APPLICATION NO: 2016/0143

DESCRIPTION: Erection of two storey side / rear extension to dwelling

LOCATION: 71 Huddersfield Road, Barnsley S75 1AF

PROPOSED FIRST FLOOR

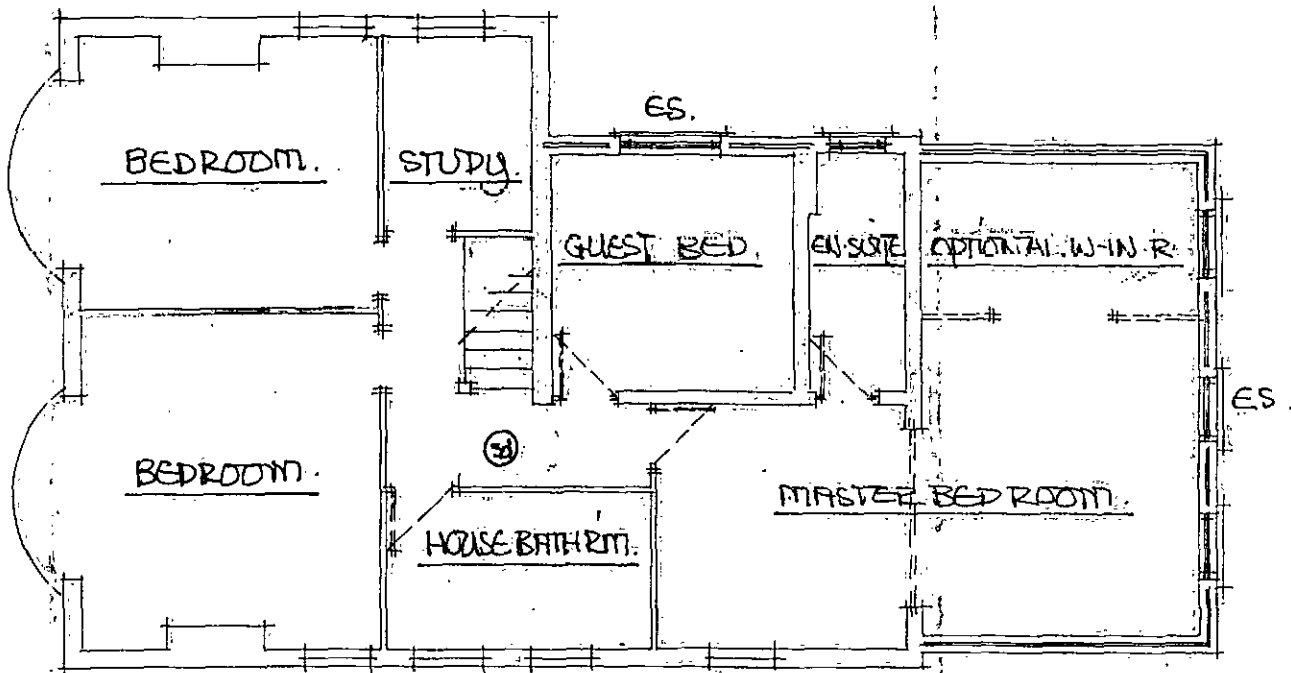
The start point for our concern is the size and extent of the rear projection of the master bedroom. To be clear at the outset, we have no objections to the family room extension at ground floor level, nor to the other part of the first floor extension. The master bedroom adds another 4.0m to the house on the elevation which faces our property, and presents a large expanse of unrelieved brickwork, topped by the roof, when viewed from our property. The position of the extension is on the west side of our property, which means that the height of the extension will have an impact on the amount of westerly evening light which reaches our garden. This will affect our garden and conservatory. The position and size of the master bedroom with its windows will also create increased potential for overlooking our garden, as the windows in the extension would be closer than at present.

2. there would be increased overlooking of our garden from the window in the master bedroom. Again this constitutes a diminution of reasonable privacy, and is not acceptable. The policy guidance does allow issues such as this to be considered, and if found to be compromised then this could be a reason for refusal.

PROP. SIDE FROM NO 69

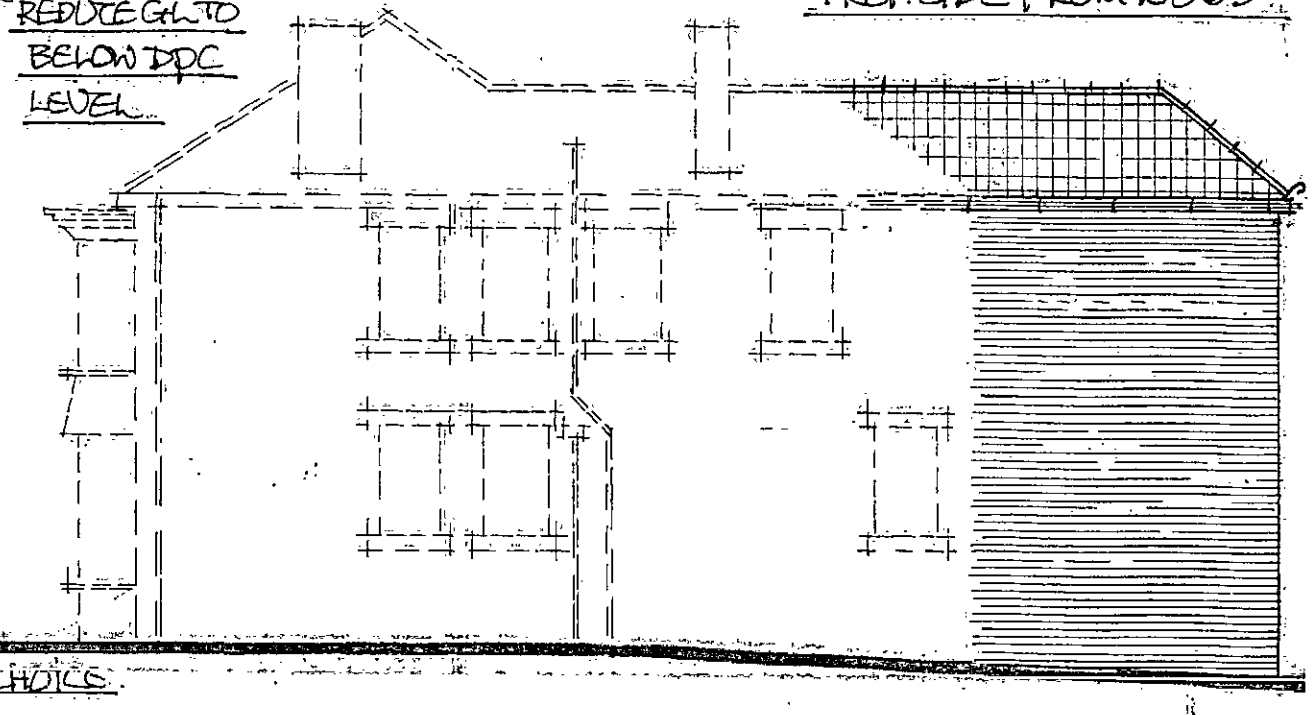
1. the amount of built mass proposed when viewed from our house is oppressive and visually highly unappealing. The view from our side kitchen window would be awful. The view from our rear bedroom window will be diminished as a result of the size of the extension, and both of these impacts are unacceptable.

3. the height of the extension would cut off evening sunlight and this loss of evening light would adversely affect both the garden area and the ambience of the aspect from our kitchen window.
